| REQUEST | Current Zoning: I-2, general industrial Proposed Zoning: MUDD-O, mixed-use development district, optional |
| LOCATION | Approximately 3.63 acres located in the block bounded by N. Davidson Street, E. 26th Street, E. 27th Street and Yadkin Avenue. |
| SUMMARY OF PETITION | <p>This petition proposes to allow a mixed-use development of up to 200 multi-family residential units, 31,000 square feet of retail, with the ability to convert to office and 9,000 square feet for a restaurant, with the ability to convert to office and or retail. The Optional provisions are as follows.</p> <p>Continue to allow existing parking located between E. 27th Street right-of-way and the existing building. Steps and retaining walls may be located in the setbacks along N. Davidson Street to accommodate grade change. A roof-top patio may be added to the building at the corner of N. Davidson Street and E. 27th Street. Design Flexibilities for the N. Davidson Street trees and sidewalk.</p> |

PLANNING STAFF REVIEW

RZ-1.0

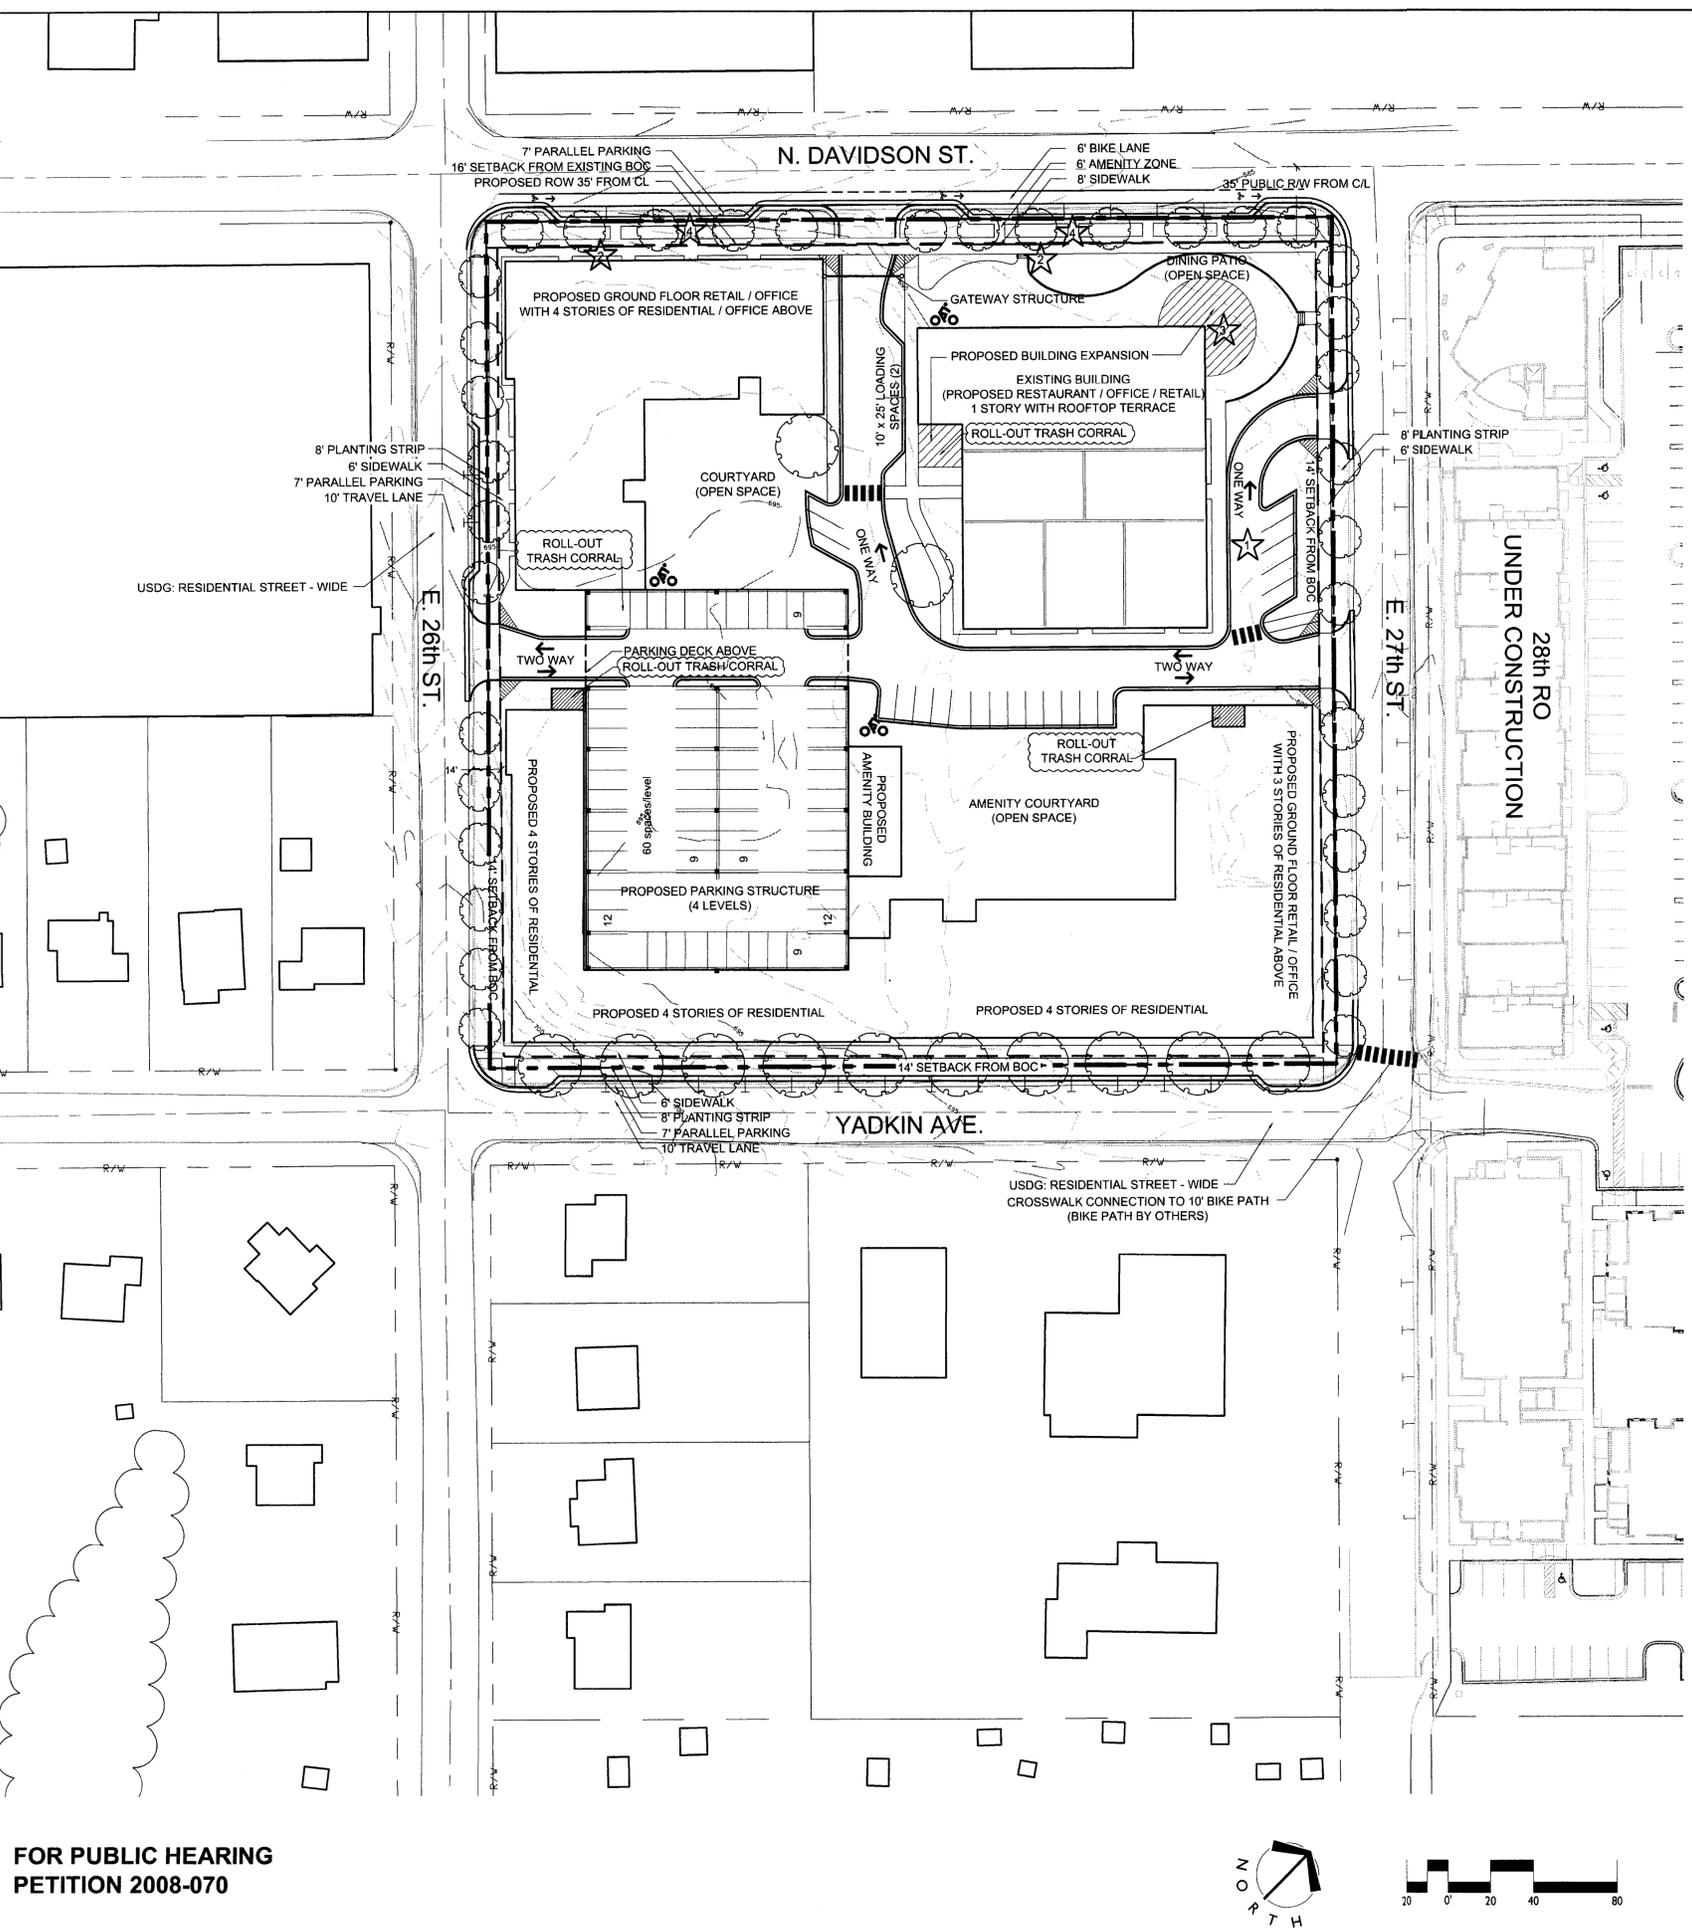
CDOT: We typically request traffic impact studies for developments that result in more than 2,500 additional trips per day. Because the site is location within ¼ mile of a proposed transit station area and existing street network in the area, we will not request that a traffic study be prepared. As shown on the site plan, access to the dumpster by waste collection vehicles is blocked by parking spaces. The site plan needs to be revised to show unimpeded access.

1. The Petitioner should address CDOT's issue with dumpster location.
-
